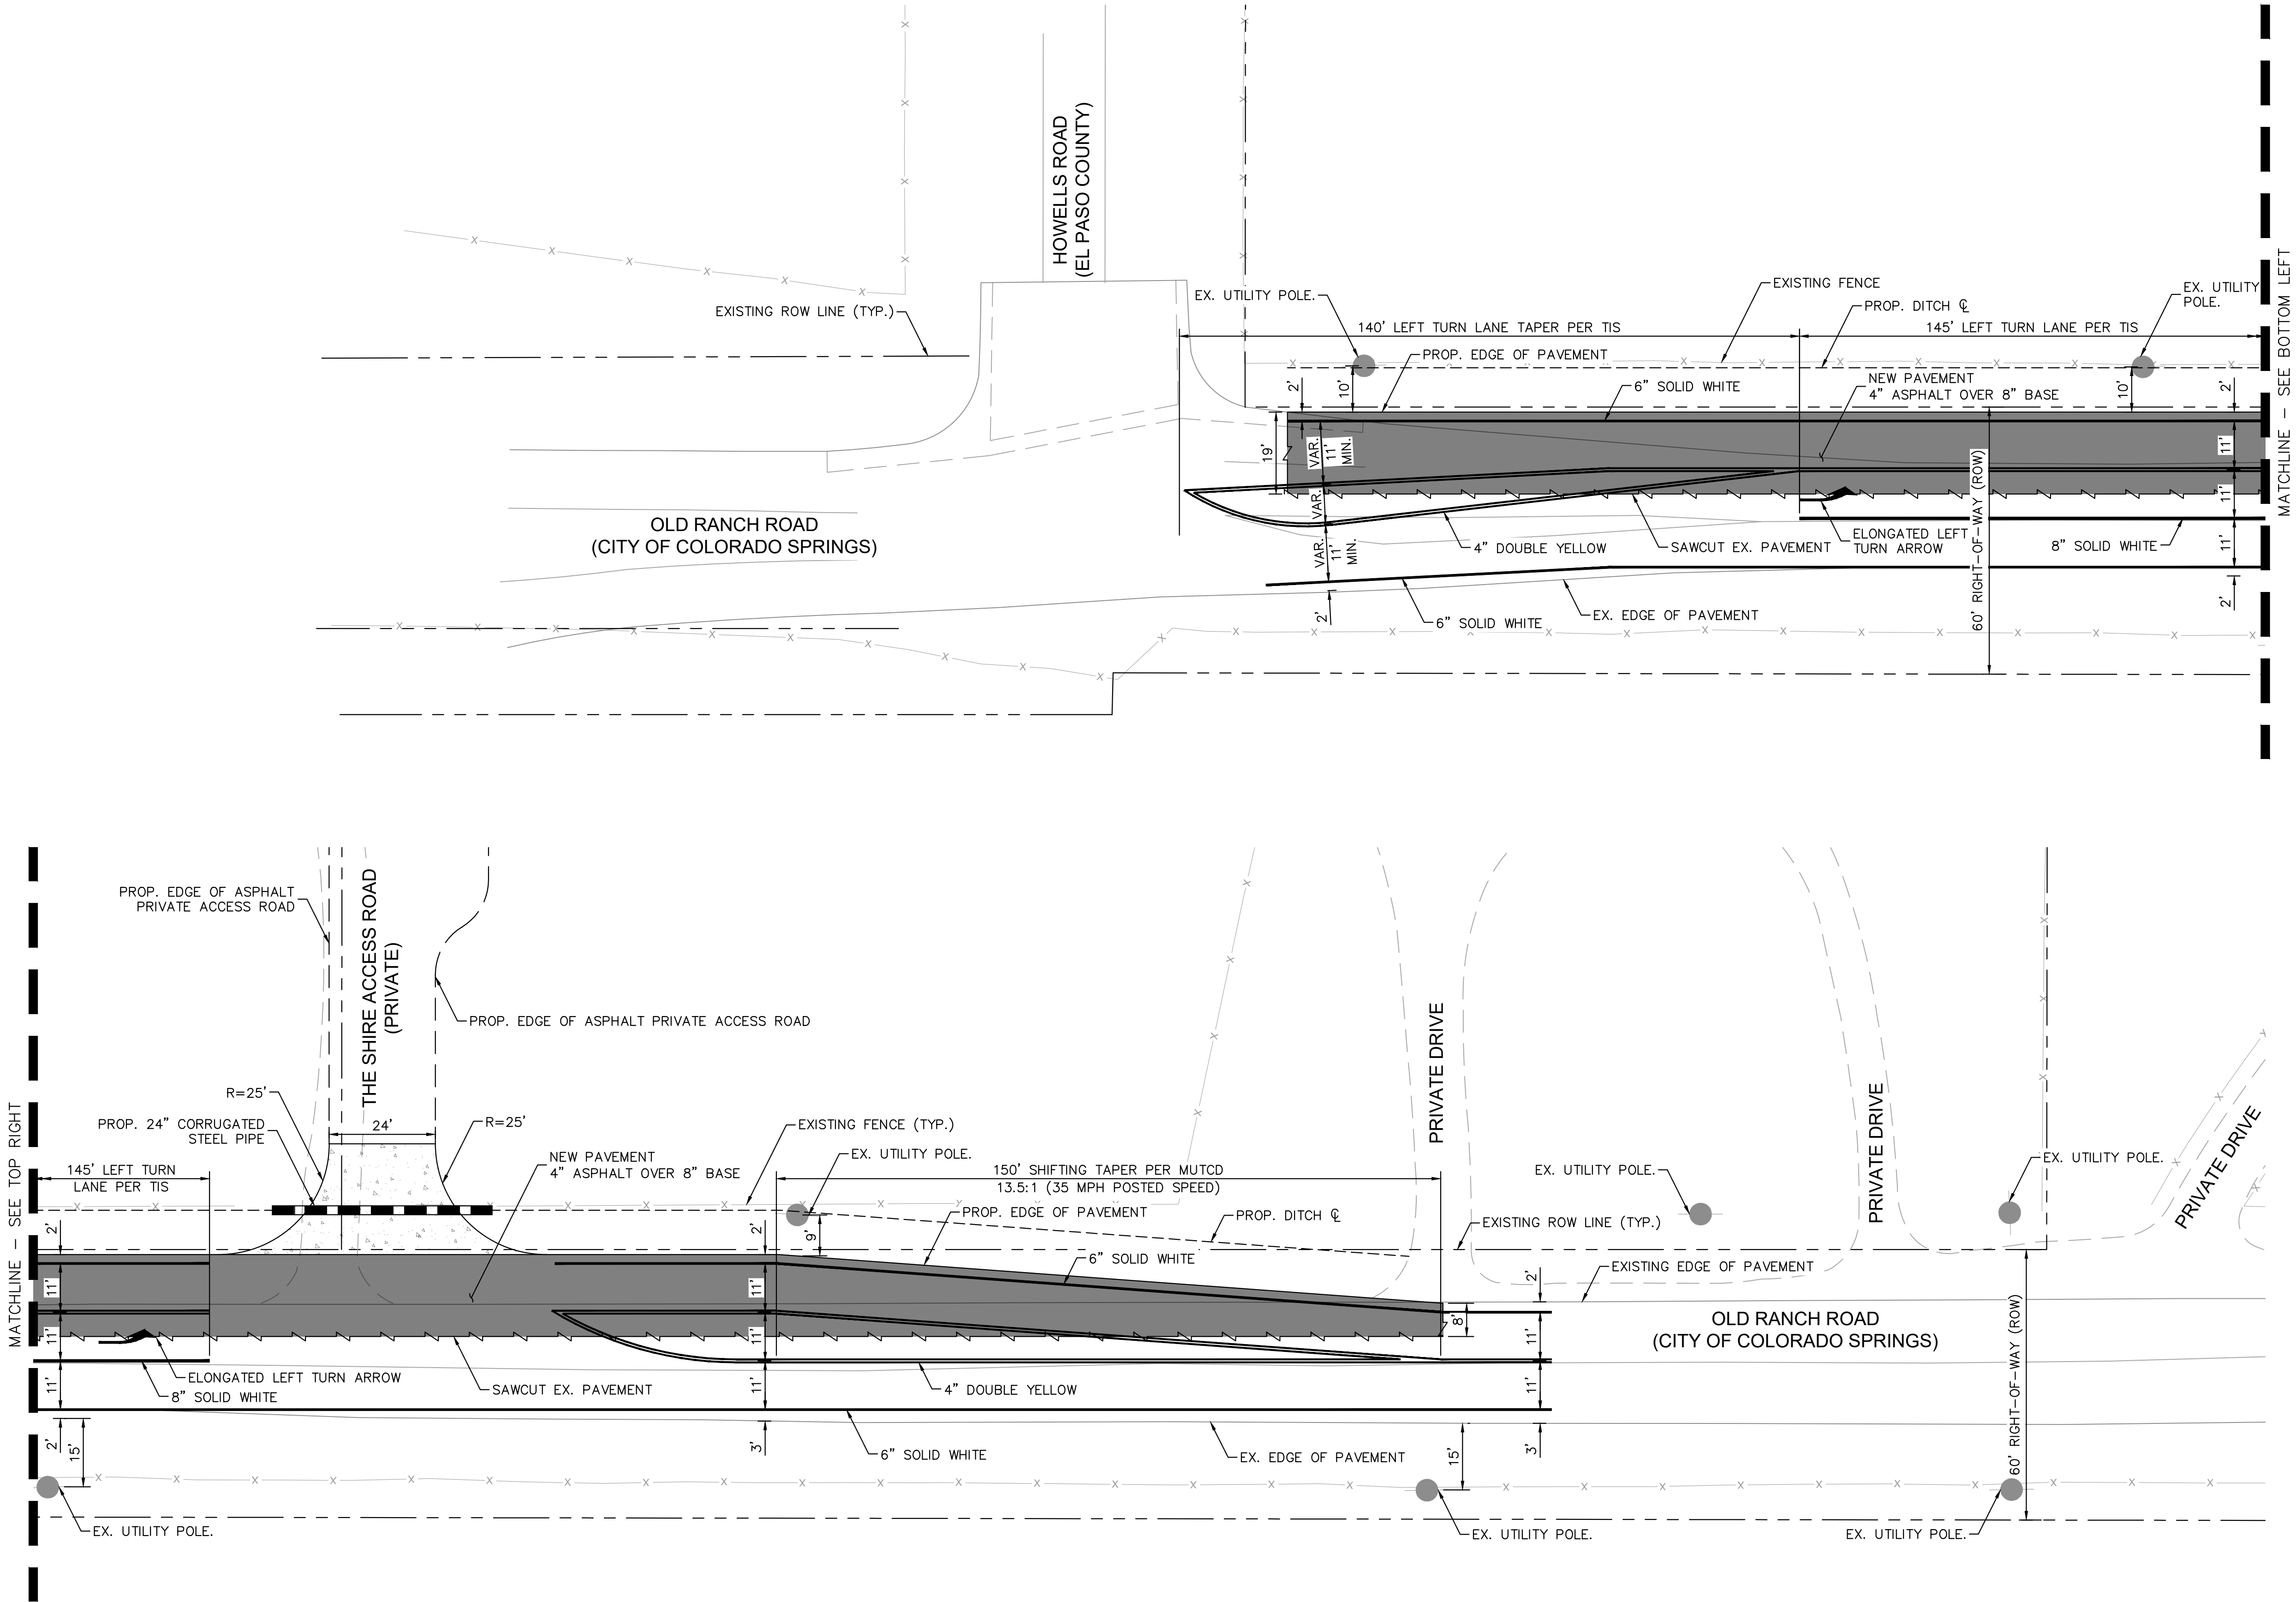
Please be sure to coordinate with the City of Colorado Springs for all requirements on public improvements.

Missing coversheet with signature blocks, notes, etc.

See City comments regarding ROW
